From: Speakman, Glenn - Oxfordshire County Council
<Glenn.Speakman@Oxfordshire.gov.uk>
Sent: 17 February 2022 11:09
To: John Cosgrove; DC Support
Cc: Planning Consultations - E&E
Subject: 21/02376/DISC E P Barrus Ltd, Launton Road, Bicester, OX26 4UR

Application no: 21/02376/DISC

Location: E P Barrus Ltd, Launton Road, Bicester, OX26 4UR

Transport Development Control

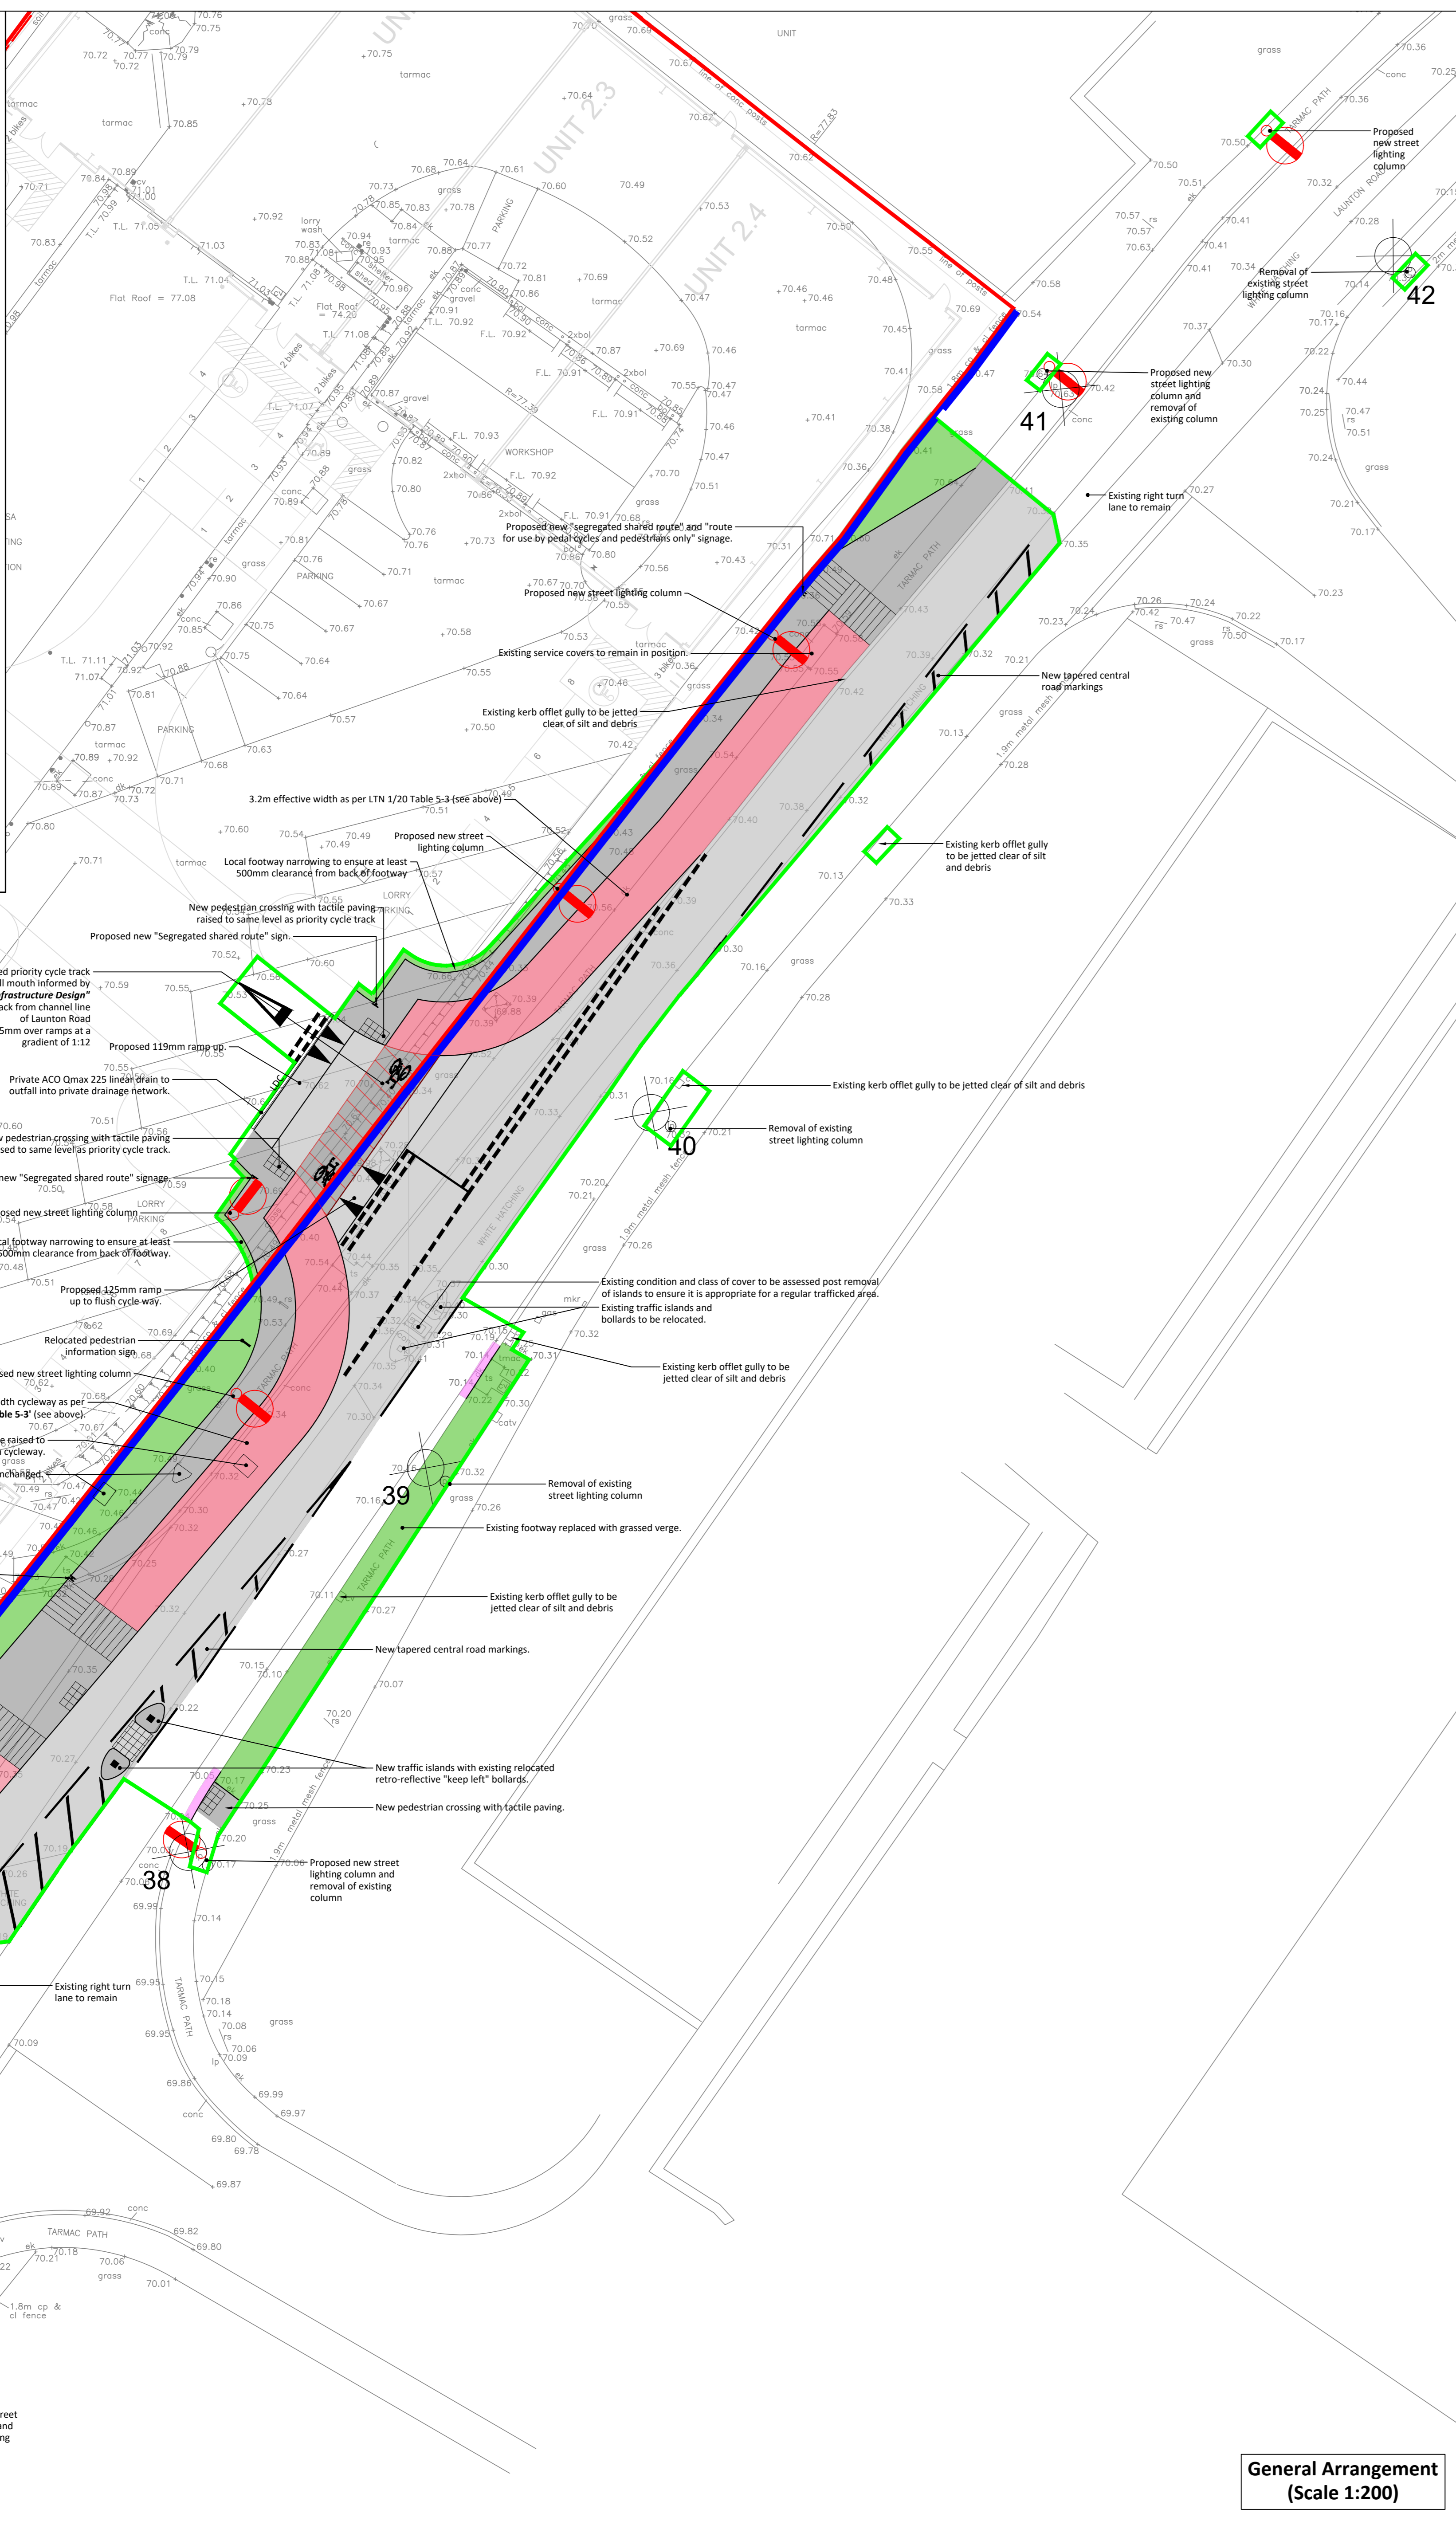
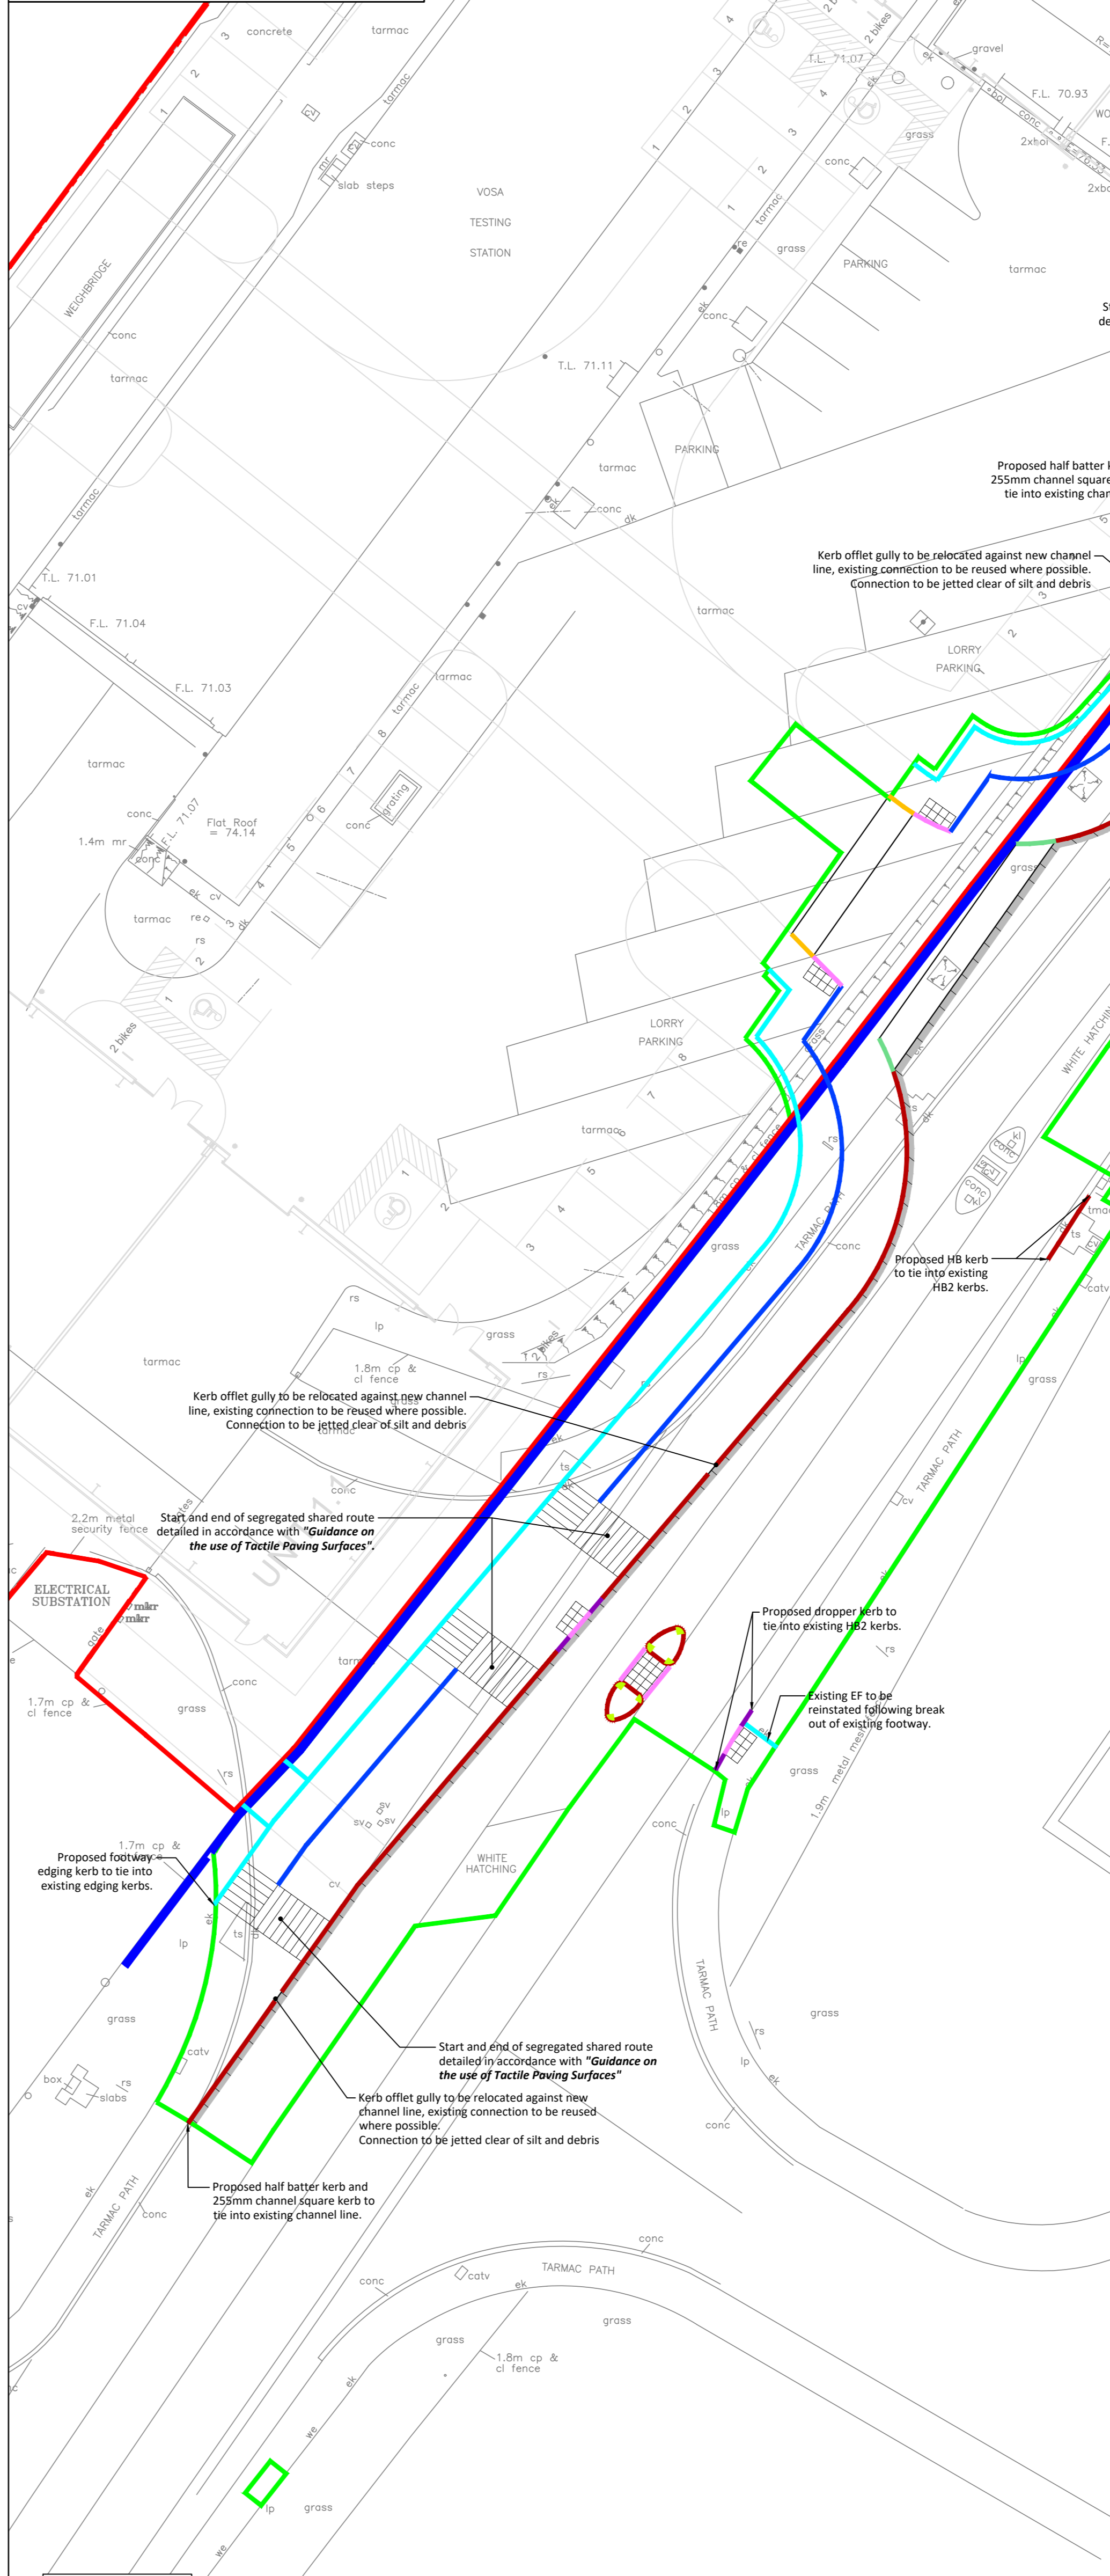
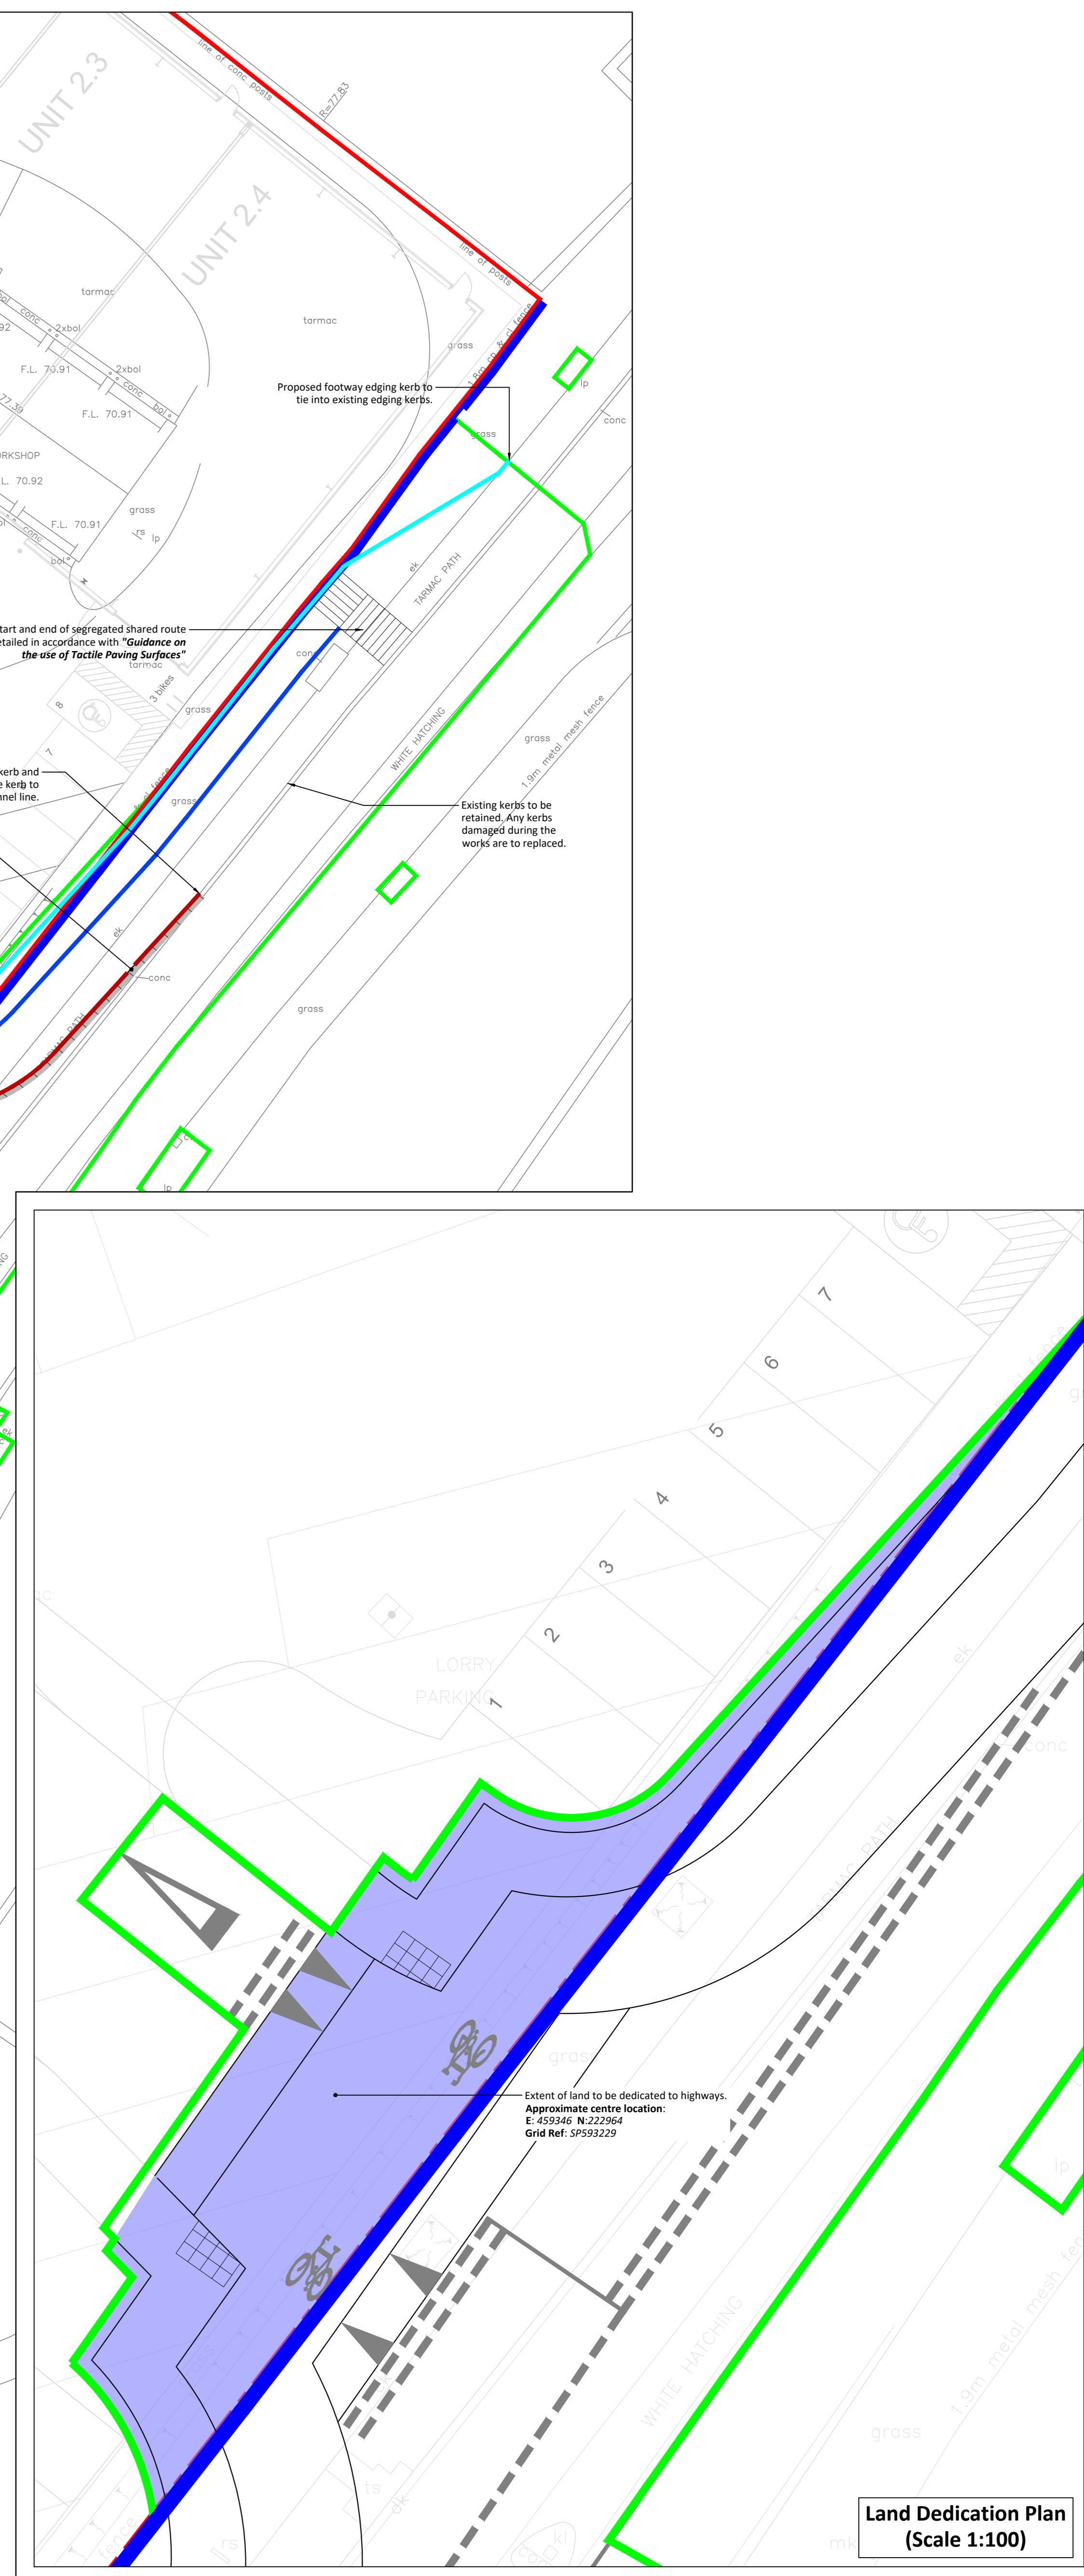
Condition 4 - Since our previous response to application no. 20/02139/F, it has become clear that the means of access to the site should be fully LTN1/20 compliant. This entails a fully segregated cycle/pedestrian path along the frontage of the site including a 3m wide cycle path, 2m wide footpath and fully set back crossing facility. The applicant has submitted updated drawings which show an LTN1/20 compliant solution to the access.

The ghost right turn lane has been removed. On balance, the benefits to cyclists and pedestrians were considered to outweigh any potential disruptions to the flow of traffic which remain unlikely. The proposals are now considered LTN1/20 compliant and as such, OCC do not object to the discharge of condition 4 (means of access)
